3/17/26

I-5719B_U5800_Submittal S-008-4B Plans
MI-Engineering- Hydraulics Review

PROJECT REFERENCE NO. L-5719B / U-5800	SHEET NO. 07
RW SHEET NO.	
ROADWAY DESIGN ENGINEER	HYDRAULICS ENGINEER
DOCUMENT NOT CONSIDERED FINAL UNLESS ALL SIGNATURES COMPLETED	
HDR Engineering, Inc. of the Carolinas 555 Fayetteville St, Suite 900 Raleigh, N.C. 27601 N.C.B.E.L.S. License Number: F-0116

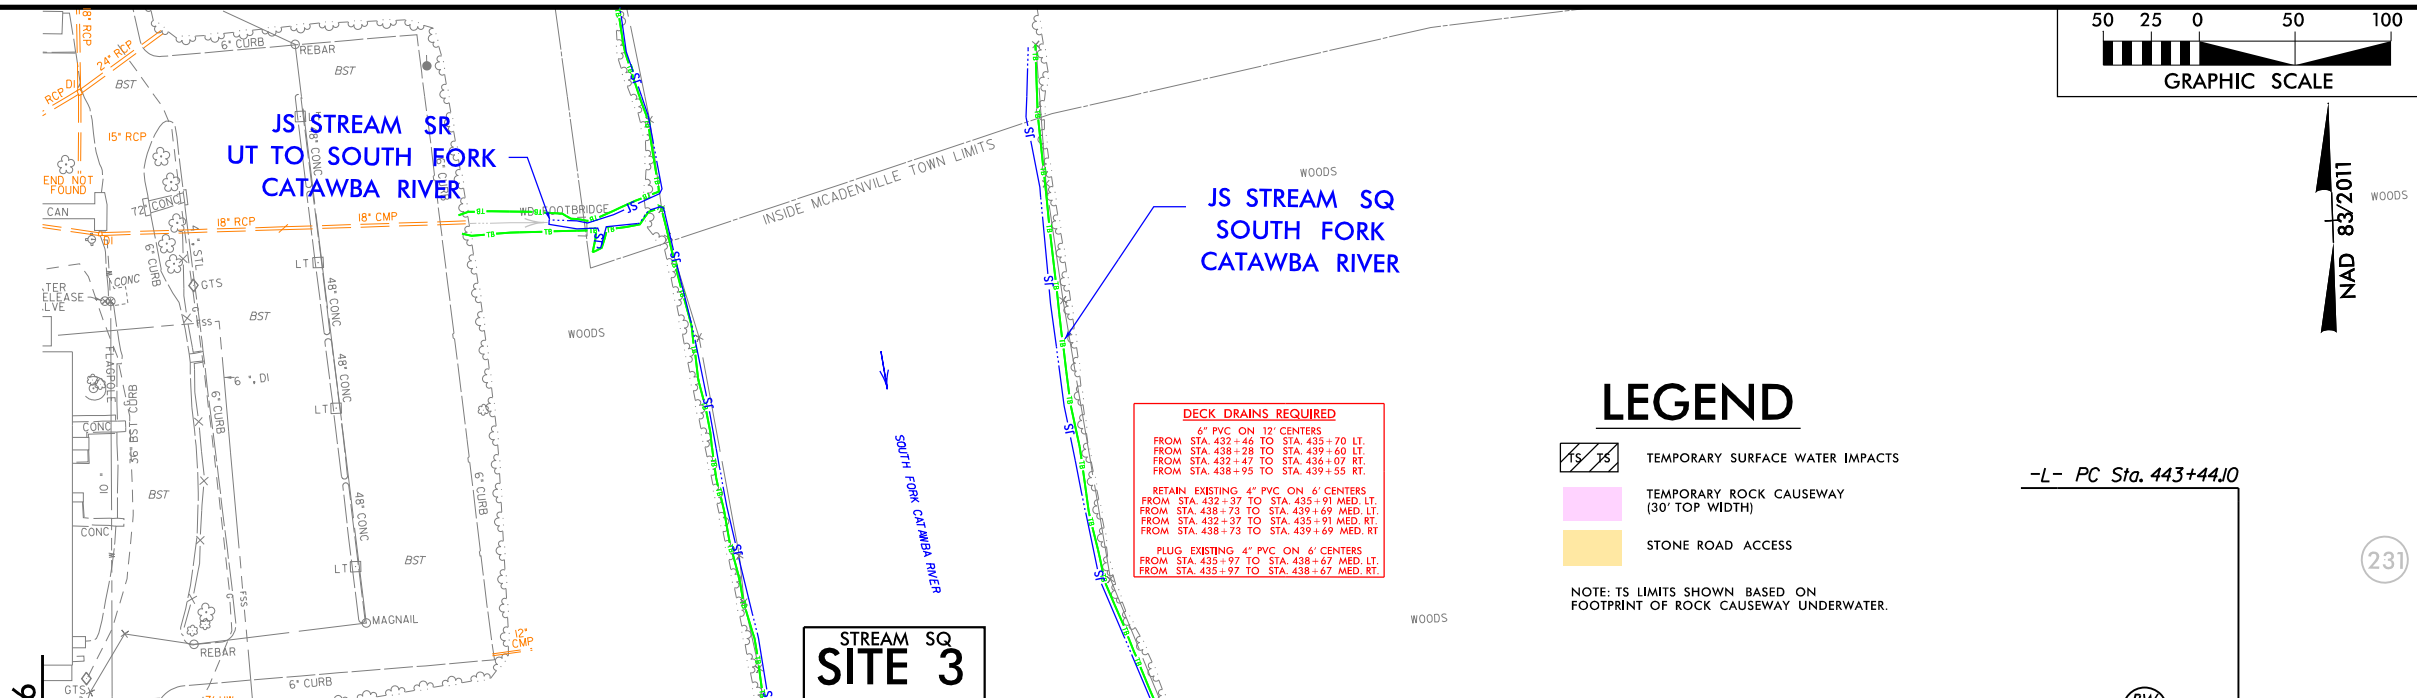
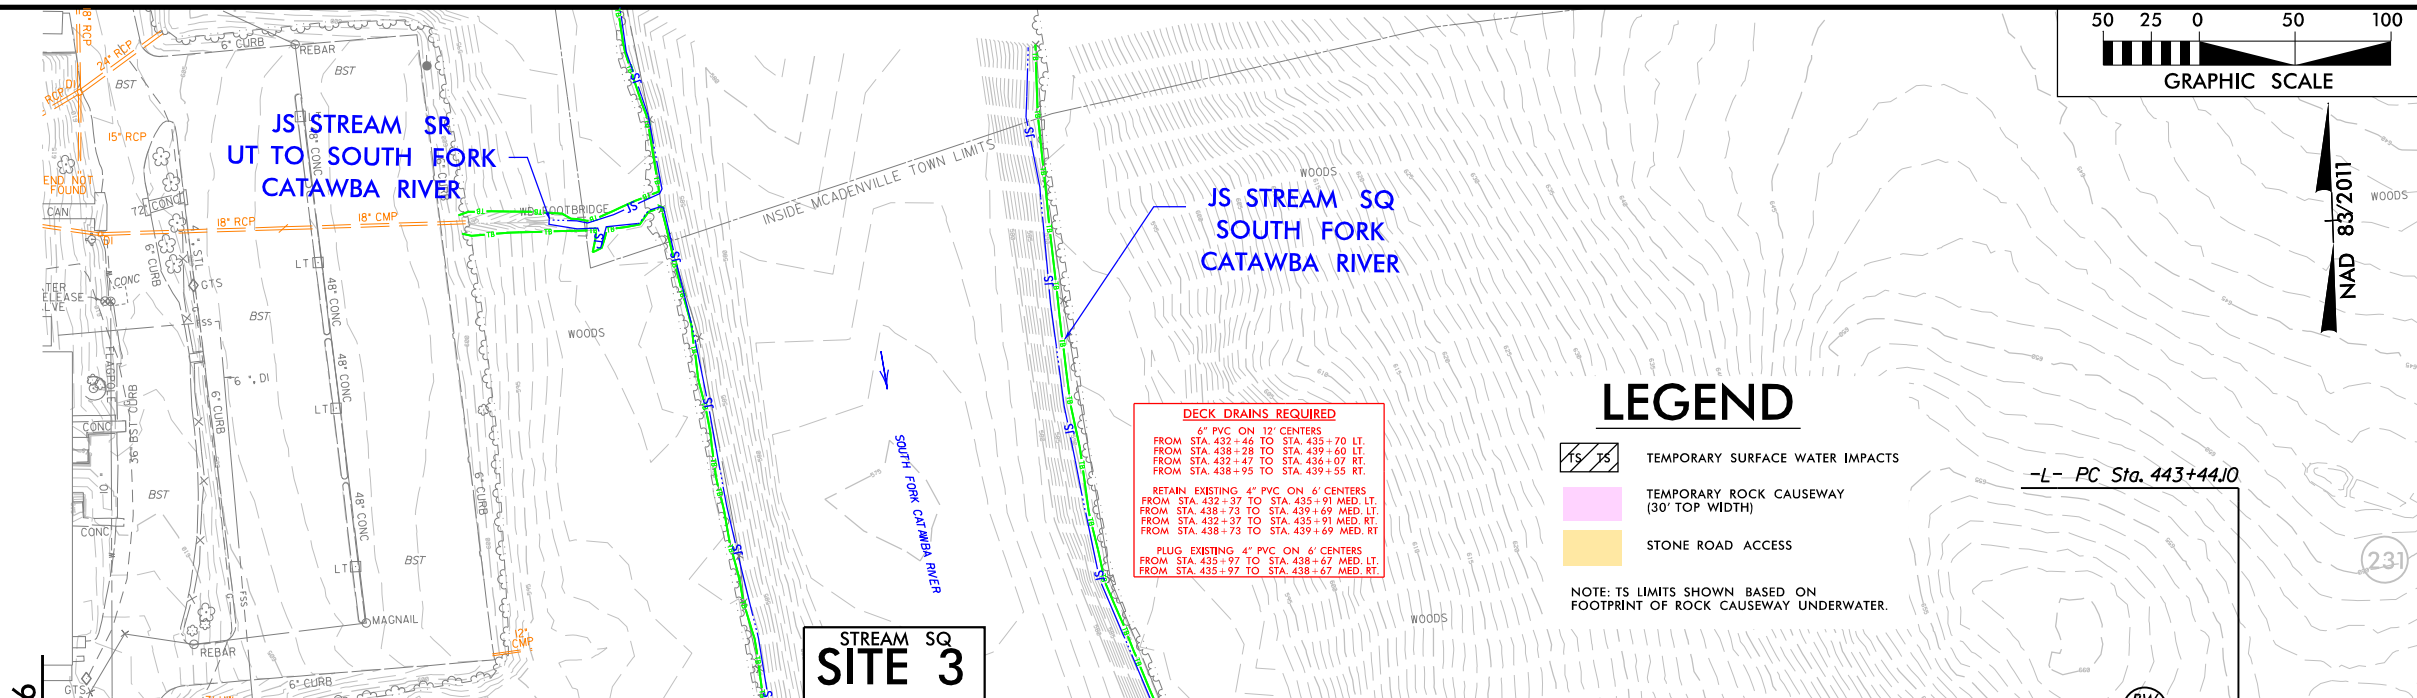
- Check deck drain stations. (see markup)
 - Deck drain stationing updated.

PROJECT REFERENCE NO. L-5719B / U-5800	SHEET NO. 08
RW SHEET NO.	
ROADWAY DESIGN ENGINEER	HYDRAULICS ENGINEER
DOCUMENT NOT CONSIDERED FINAL UNLESS ALL SIGNATURES COMPLETED	
HDR Engineering, Inc. of the Carolinas 555 Fayetteville St, Suite 900 Raleigh, N.C. 27601 N.C.B.E.L.S. License Number: F-0116

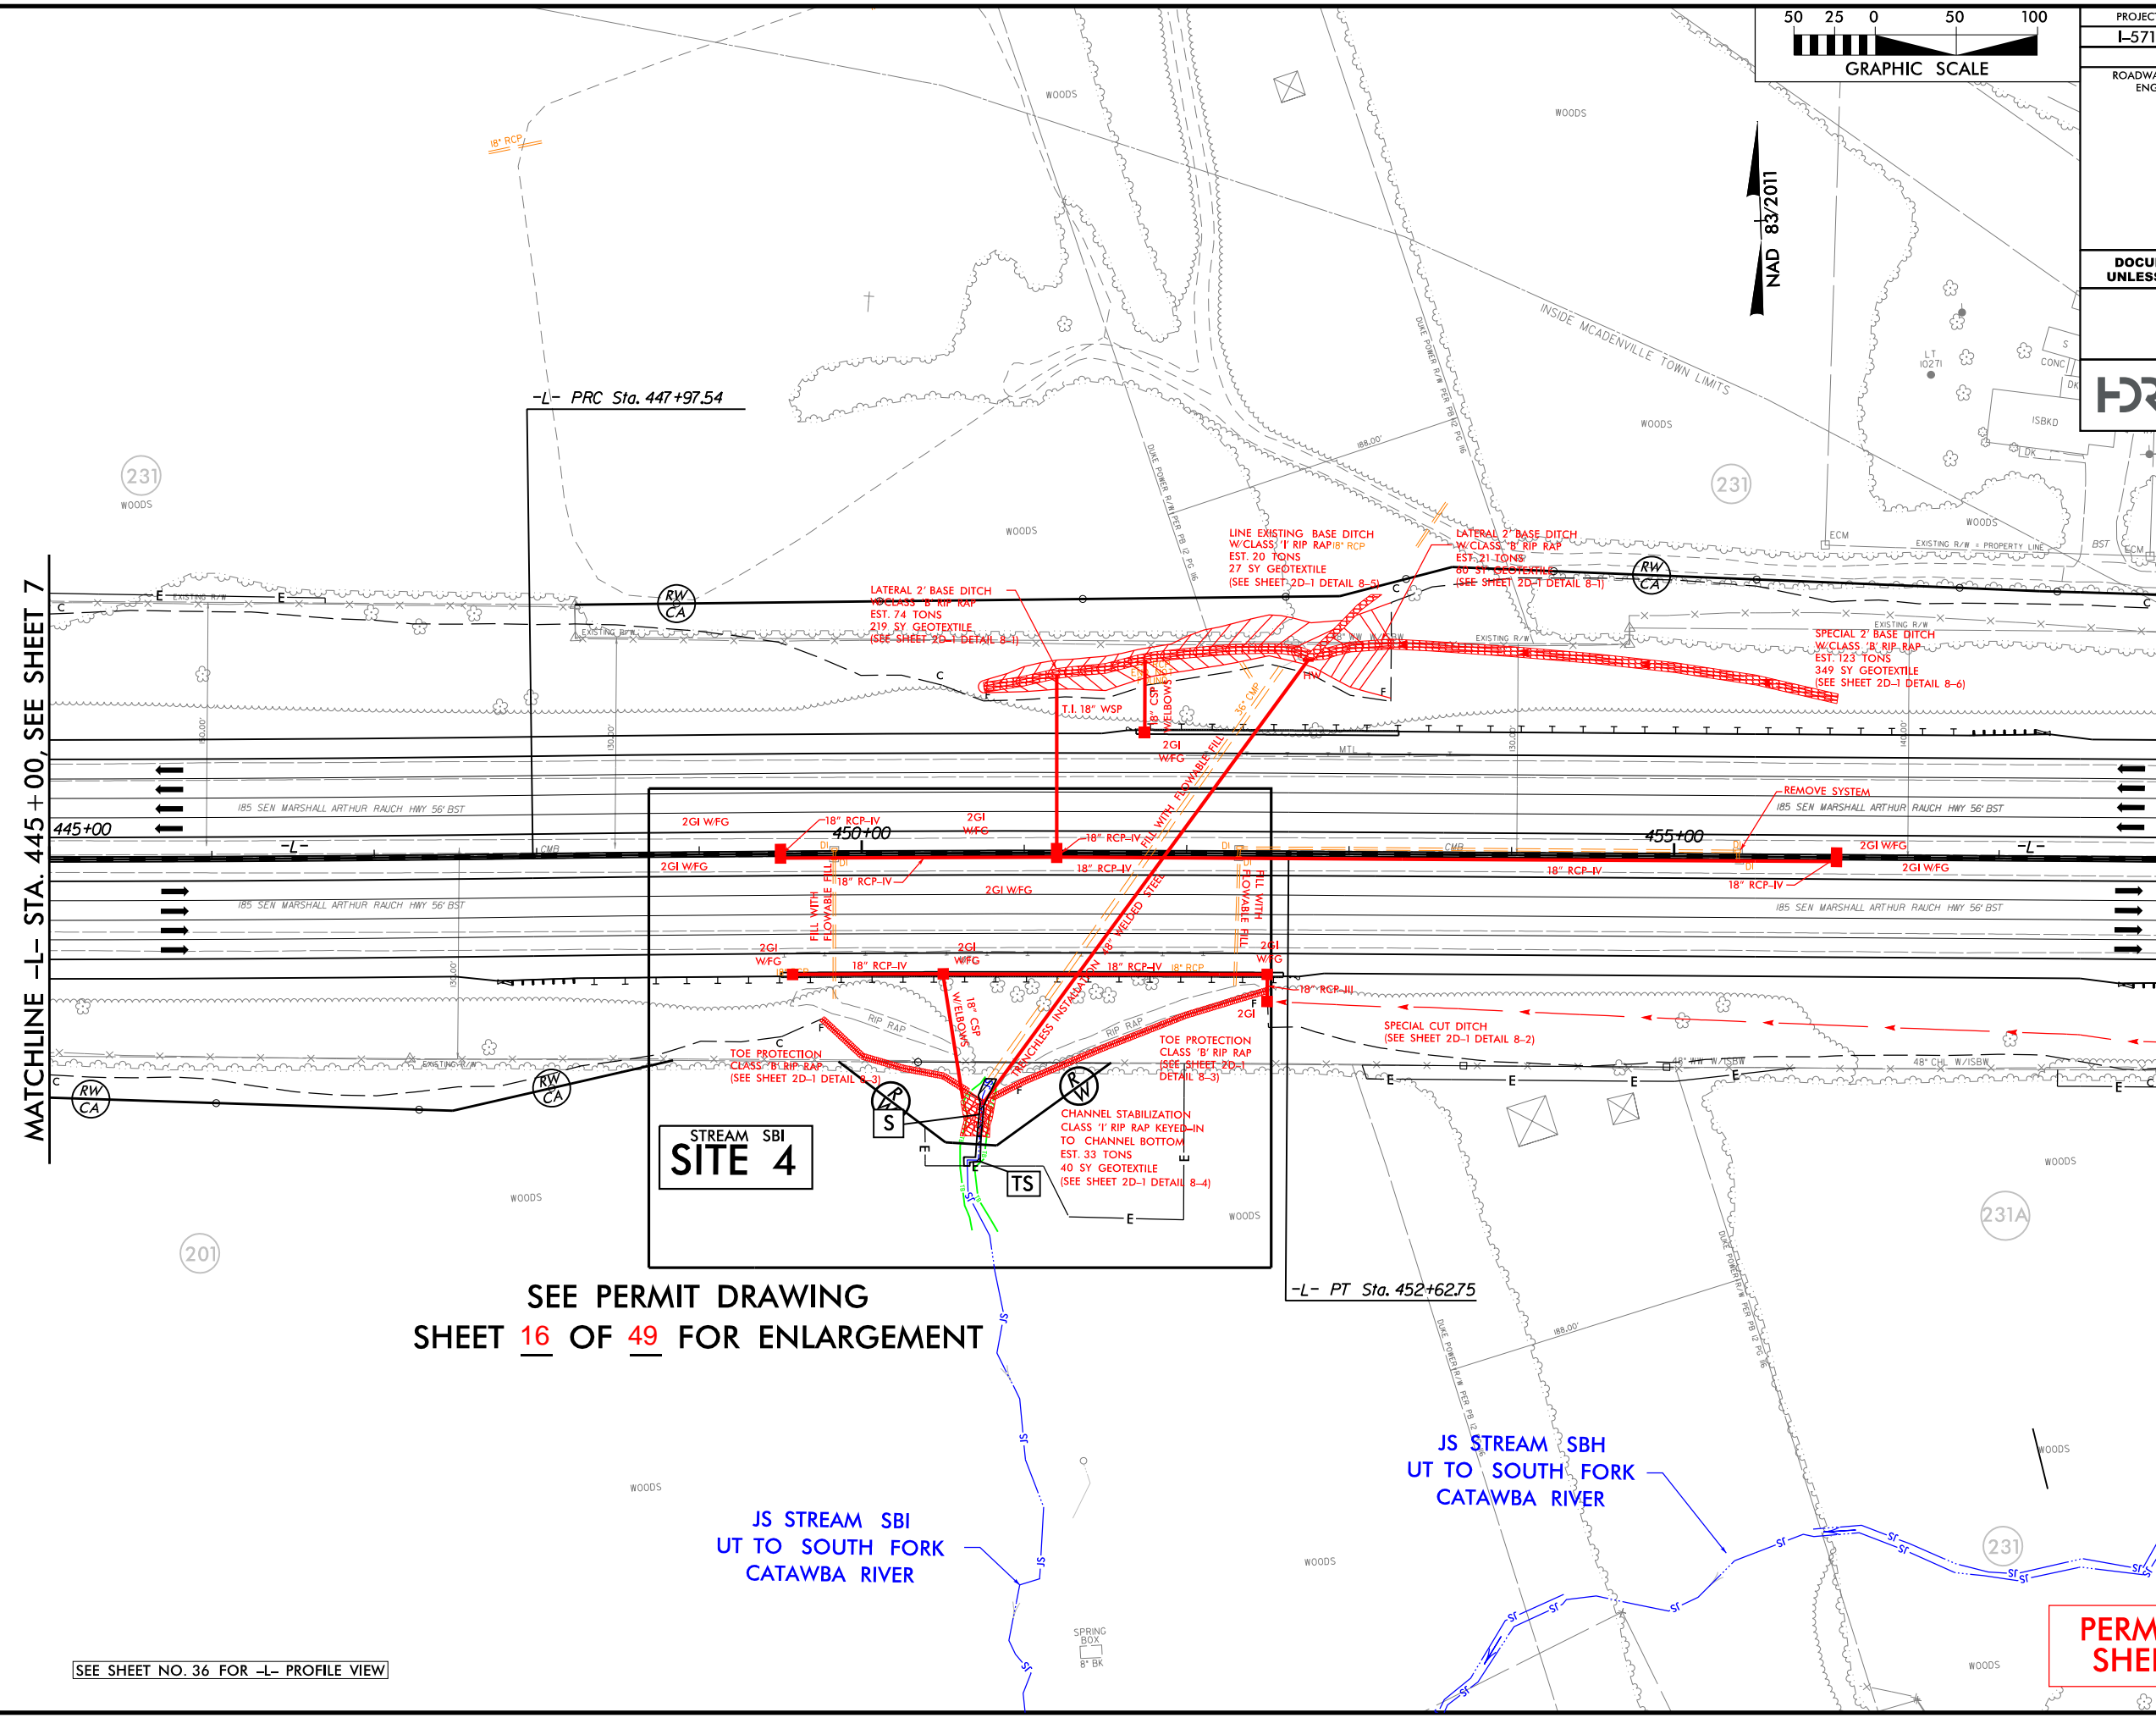
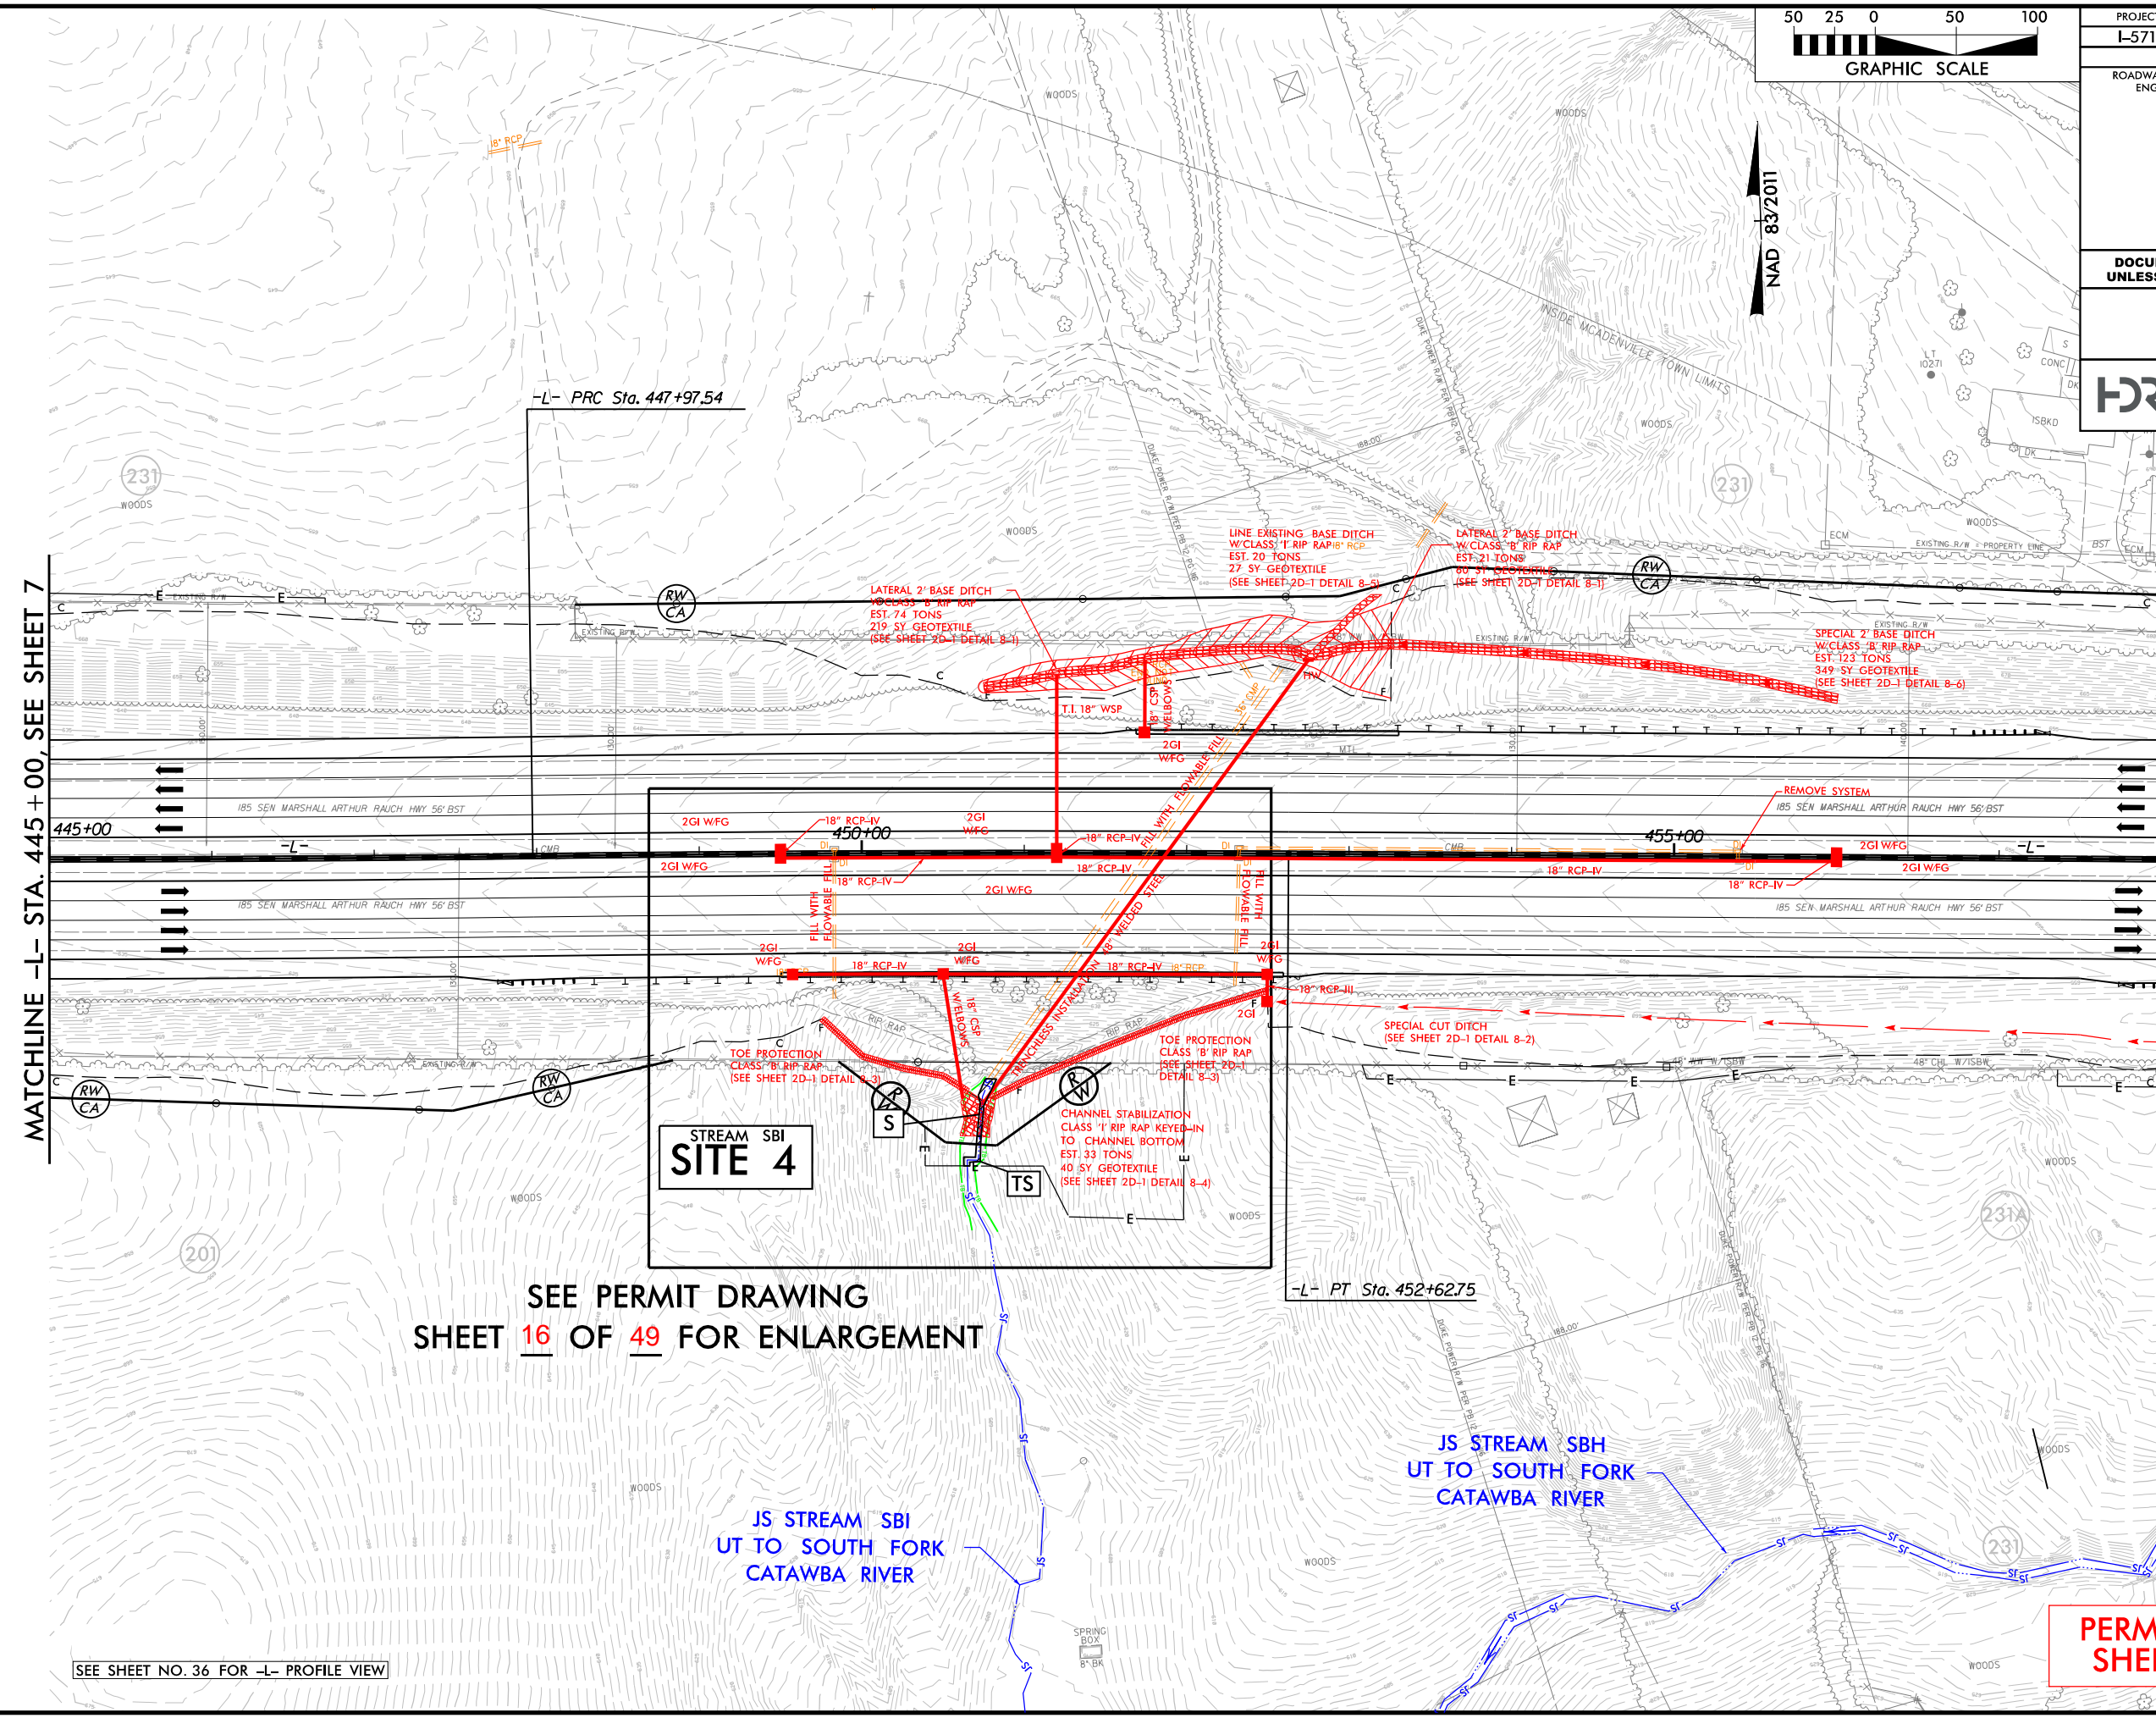
- Would it be possible to drain median to left side ditch to minimize direct connections from impervious surfaces to the receiving waters to the maximum extent practicable? per RFP PAGE 406. See mark up.
 - Should be possible, change will be incorporated during redline reviews.
- Recommend keying rip rap into stream bed at outlet of 48" pipe since it is the beginning of the stream at the outlet and outlet velocity is high based on pipe data sheet.
 - Riprap was revised to show key-in to channel bottom.
